Our reference: P-591319-T6C6  
Contact: Jake Bentley  
Telephone: (02) 4732 8087

12 December 2023

**Council Response to Amendment Report - SSD-17552047 – The Edge Estate at 155–217 Aldington Road, Kemps Creek, NSW, 2178**

MC03 LONGITUDINAL SECTION - CH0.00 to CH350.00  
 SCALE 1:500 HORI.  
 1:50 VERT.

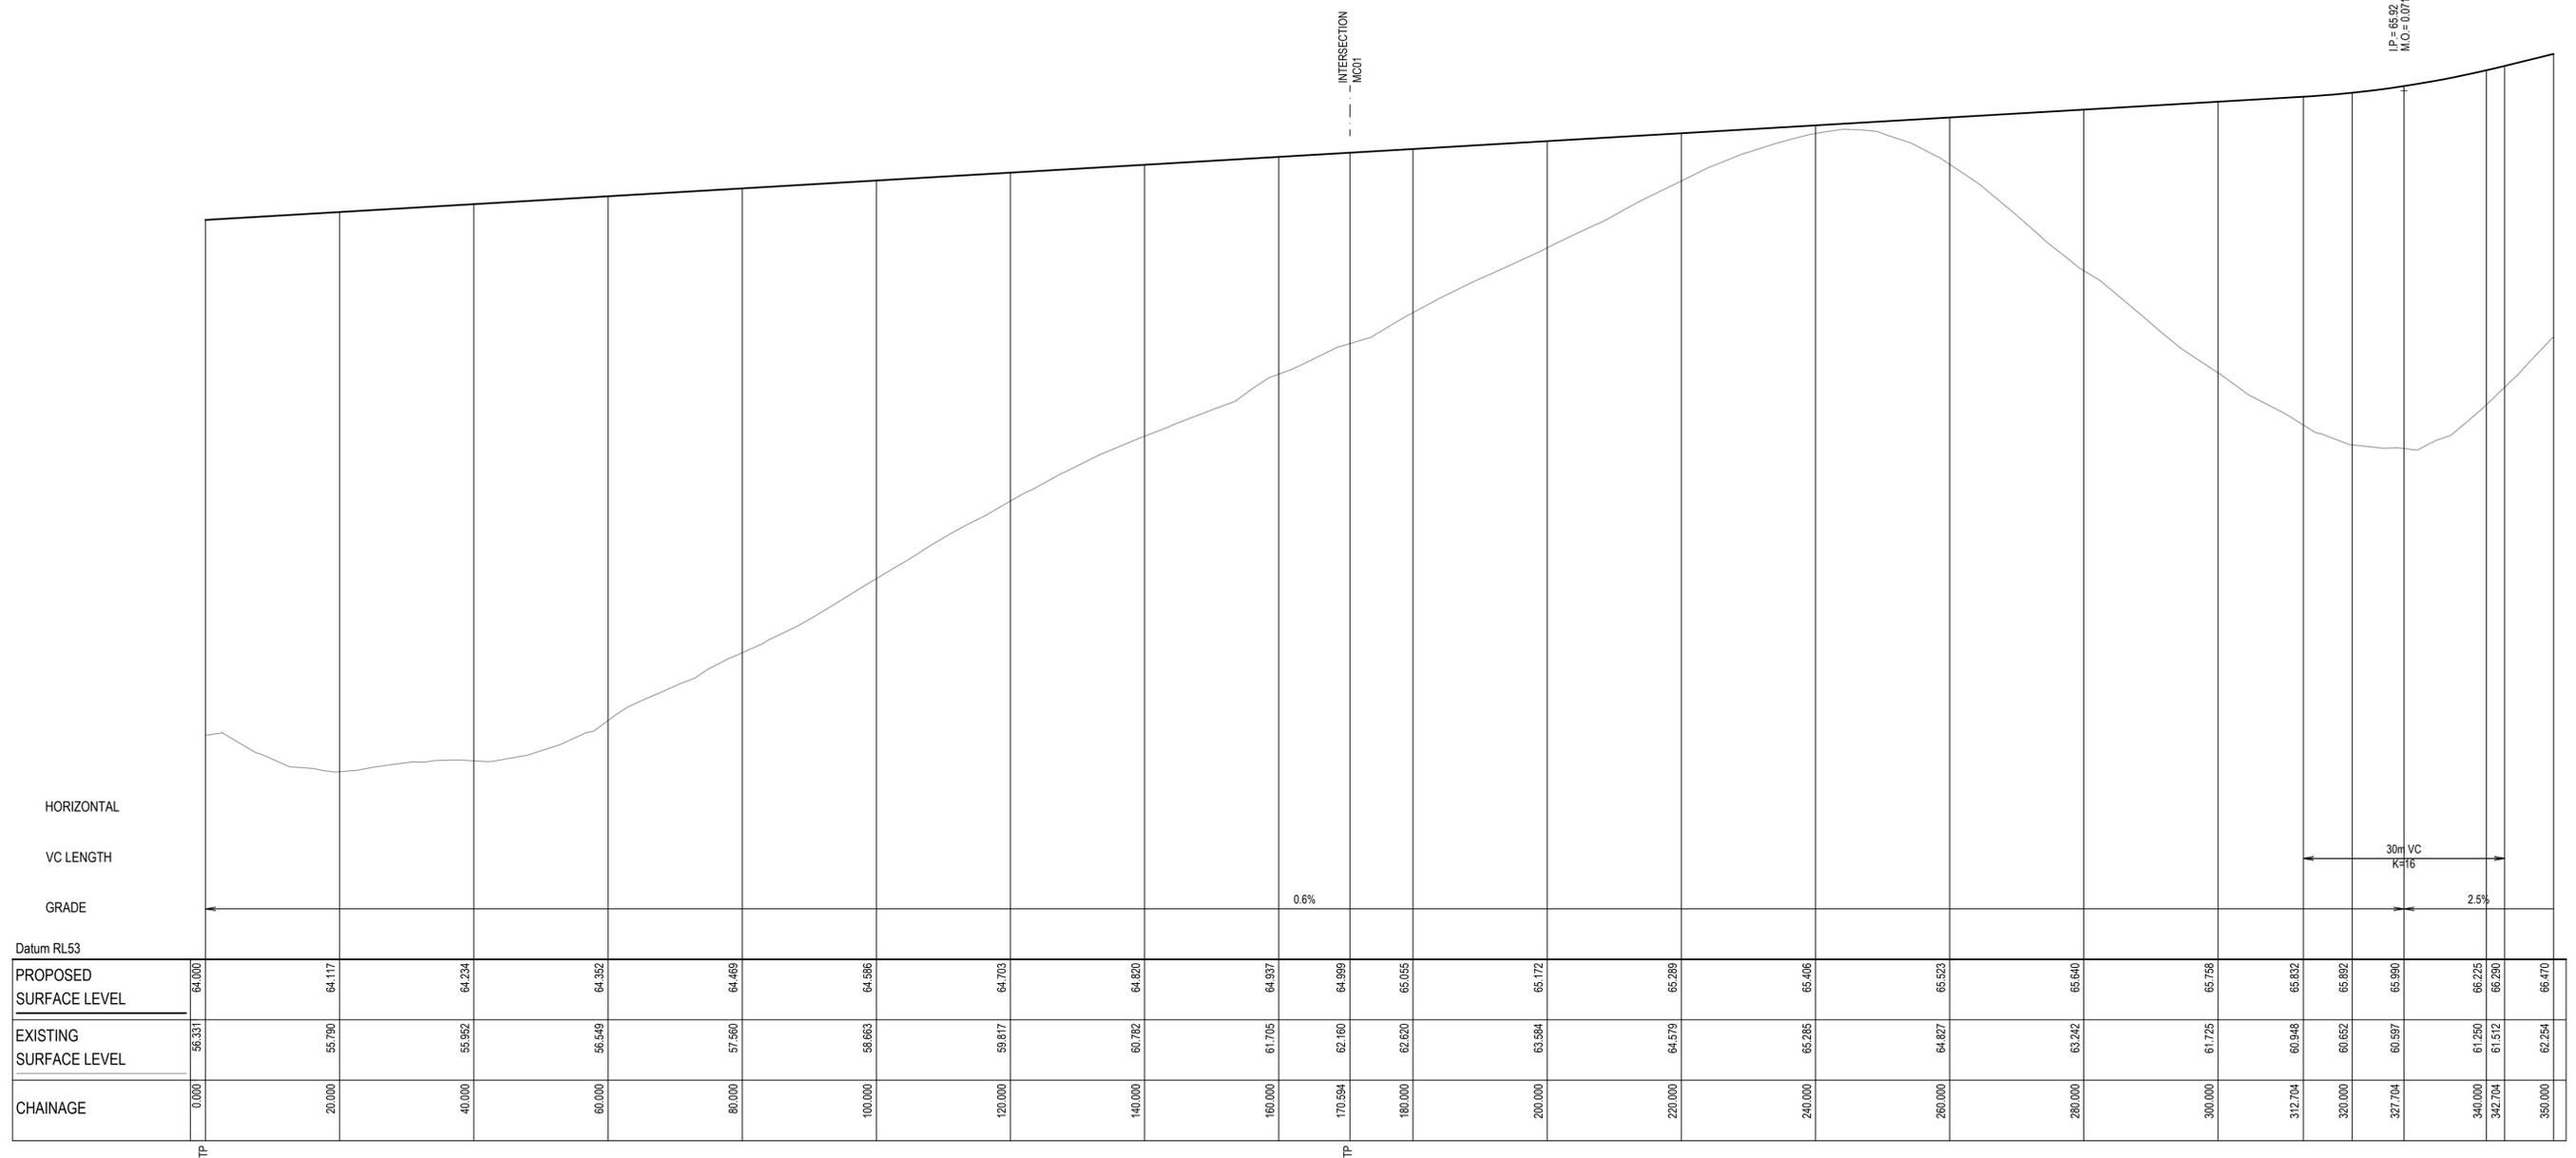
- The sag vertical curve at the intersection of Roads 02 & 03 (MC03 longitudinal section) does not appear to comply with clause 8.6.4 of Austroads Guide to Road Design Part 3: Geometric Design. Where the topography of the site permits, it should be sought to increase the length of this sag vertical curve.
- It is recommended that engineering plans are provided as part of this application that demonstrate compliant construction access to/from the site from Aldington Road in the interim scenario (prior to the upgrade of Aldington Road) should consent for this development be granted prior to completion of the Aldington Road upgrade. Construction access/egress should be tested for the largest construction vehicle proposed to access the site during construction.

1 SITE / WAREHOUSE 1 PLAN
1 : 500

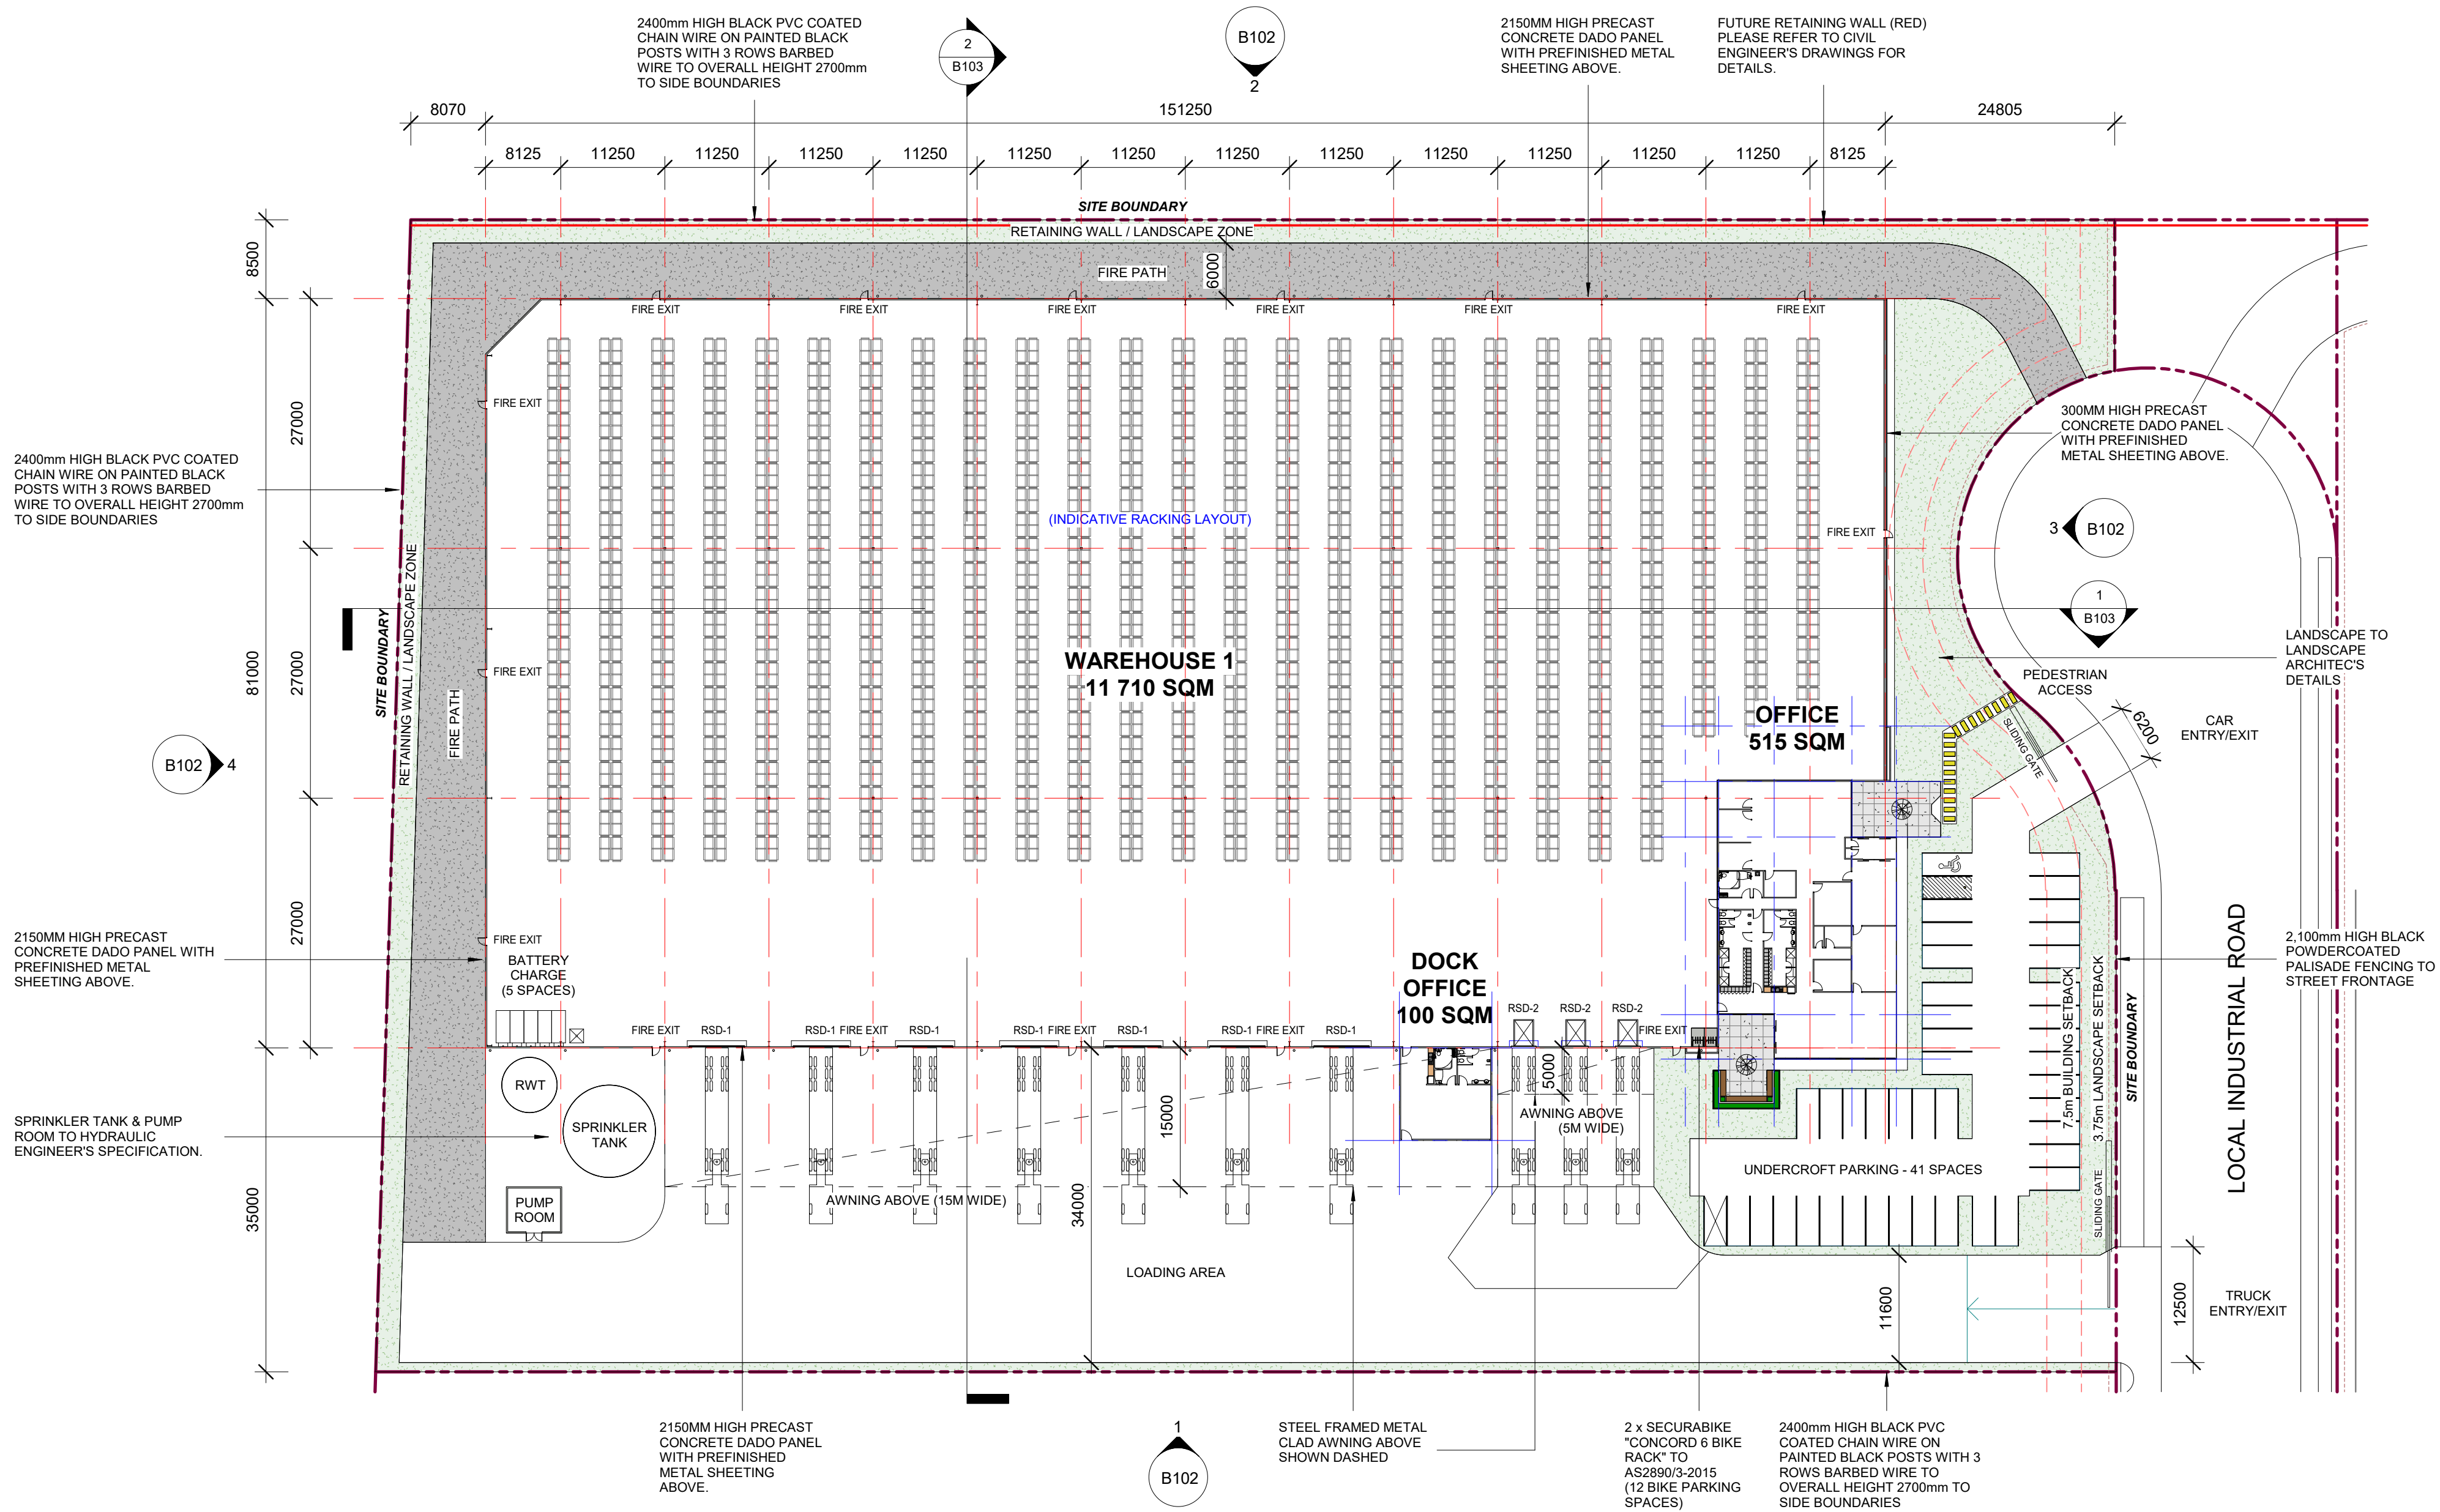
- The Site Plan for Warehouse 1 states parking amounts are insufficient.
- The Subdivision Plan shows lot 14 being accessible via proposed Road 2 via an access handle to the south of lot 13. The Department should investigate how truck and regular vehicle movement conflicts will be addressed via this arrangement.

DRAWING TITLE
SITE / WAREHOUSE &
UNDERCROFT PARKING PLAN
(WAREHOUSE 3)

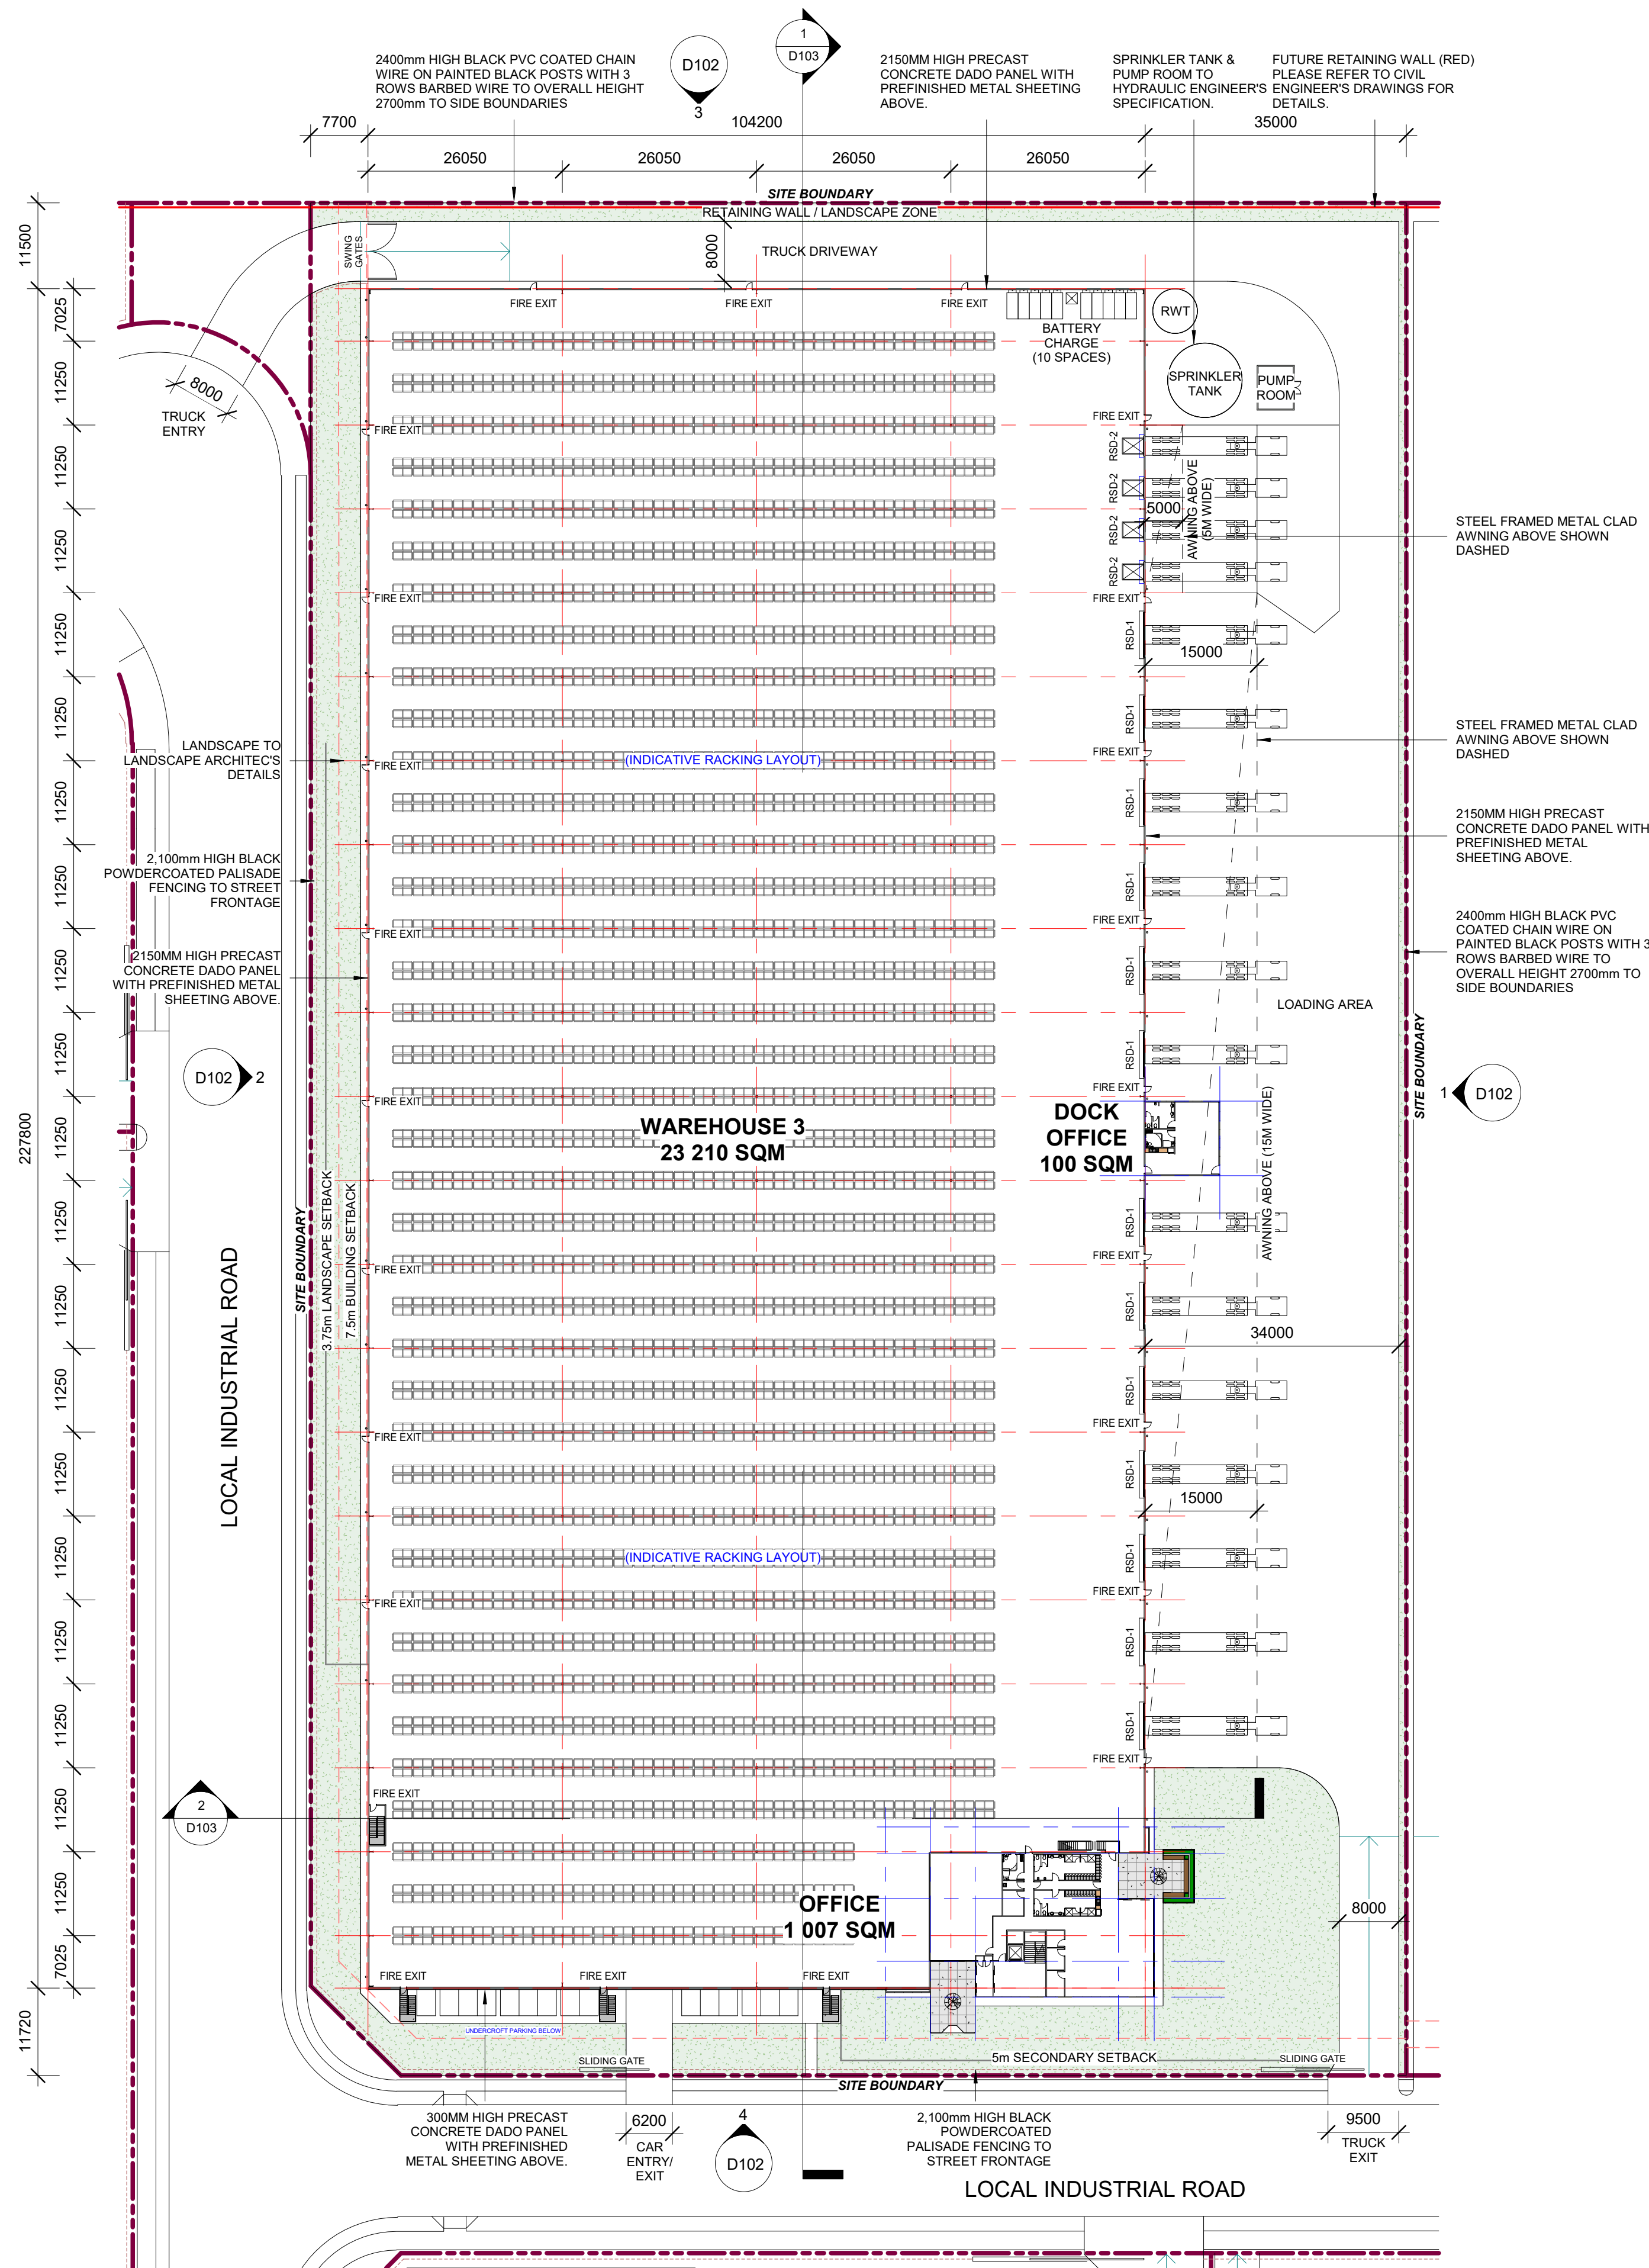
- Warehouses 3-8 incorporate undercroft parking to respond to road levels and requirement for flat building pads. As such, warehouses are elevated above the road level resulting in lack of ability for landscaping to provide effective screening.

- It is understood that a combination of retaining walls and batter is proposed to address level differences between road levels and elevated floor levels/associated loading docks. In this regard, effective landscaping to screen these areas is critical considering their elevated nature.
